## **Development Facilitation Team (DFT) – Review Comments**

**DRB Project No: PR-2022-007645 Date: 12/04/2024 Agenda Item: #4 Zone Atlas Page: J-10**

**Request: Minor Subdivision to vacate public easement for water and sewer, regranting against Western side of three existing lots.**

### **Application For: PS-2024-00154 – SKETCH PLAT**

Plat for
Lots 2-A-1 thru 2-C-1, Tract S-1
Atrisco Business Park, Unit 2
 Being Comprised of
Lots 2-A thru 2-C, Tract S-1
Atrisco Business Park, Unit 2
 City of Albuquerque
 Bernalillo County, New Mexico
 September 2024

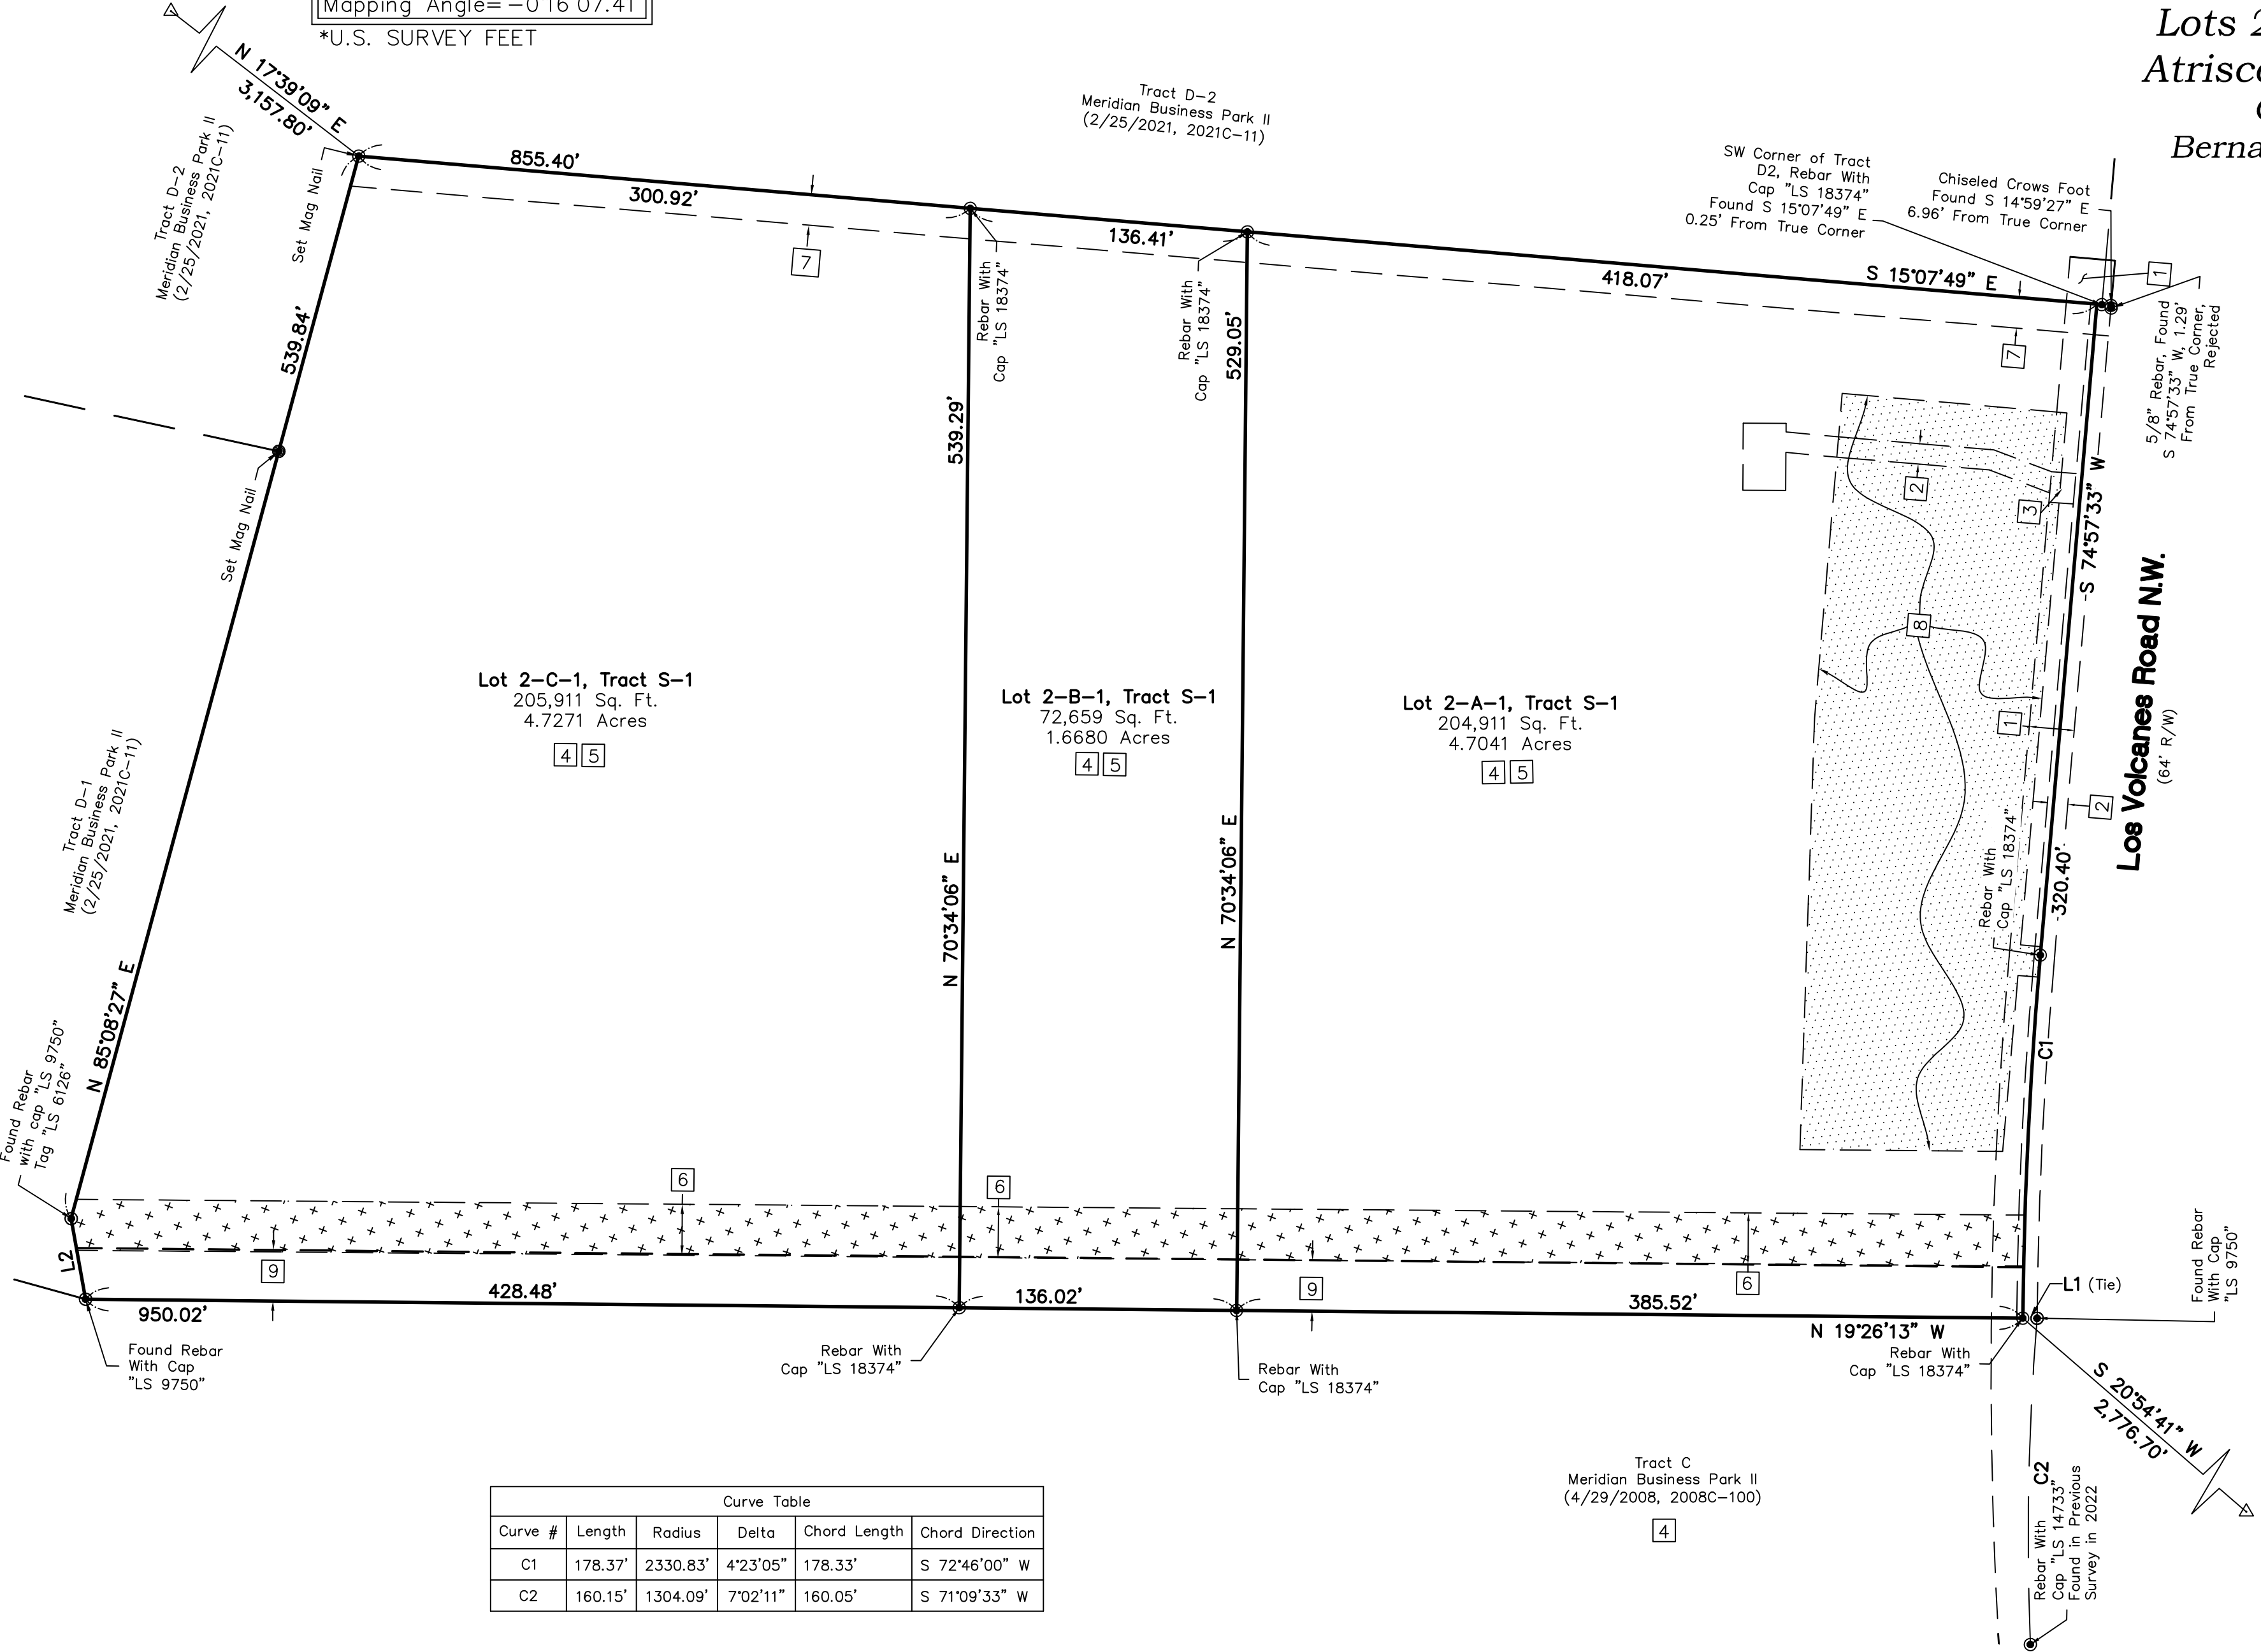
1. Confirmation with approved construction plan is needed prior to final sign off.
2. With confirmation, I have no objections to the proposed vacation or granting of new easement with the following conditions.
  - a. Please provide a trench prism showing the infrastructure and disturbances are within the proposed easement.
  - b. Provide necessary easement bump-outs for the proposed hydrants and water service as needed.
  - c. For reference please provide distances from edge of easement to the waterline and sanitary sewer line.

LANDSCAPE PLAN
LS-101

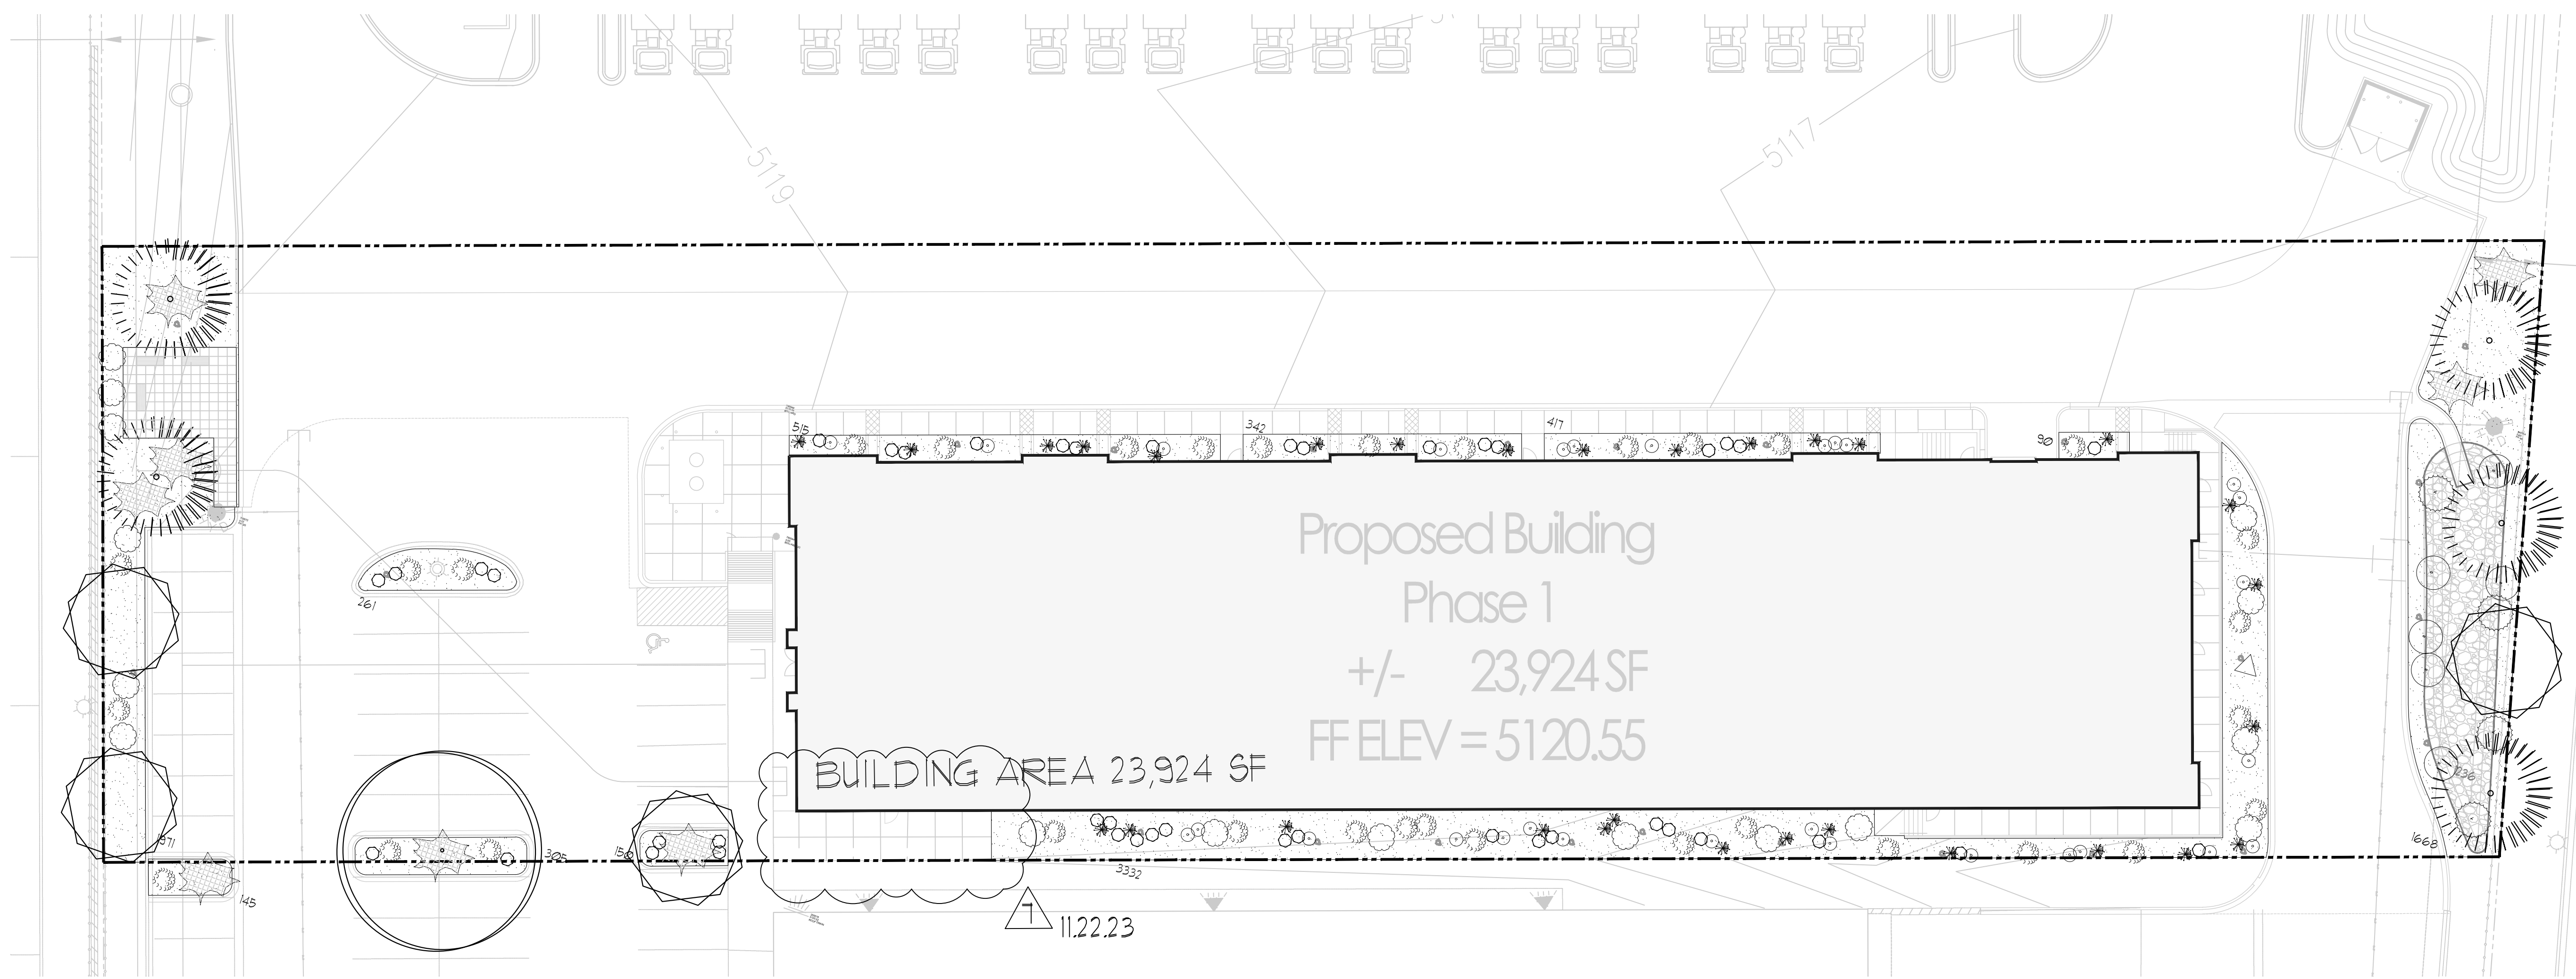
- Previously this project location had an approved Platting action and Site Plan. Within those submittal/approvals, there was an approved Landscaping Plan. There are trees in the new easement and vacated easement areas. An amendment to the Site Plan/Landscaping Plan approval will be needed in order to revise tree, and possibly shrub, locations to both avoid the utility easement and also to meet the full standards within IDO section 5-6. Please clarify and confirm that the required standards for IDO section 5-6-G are being met.
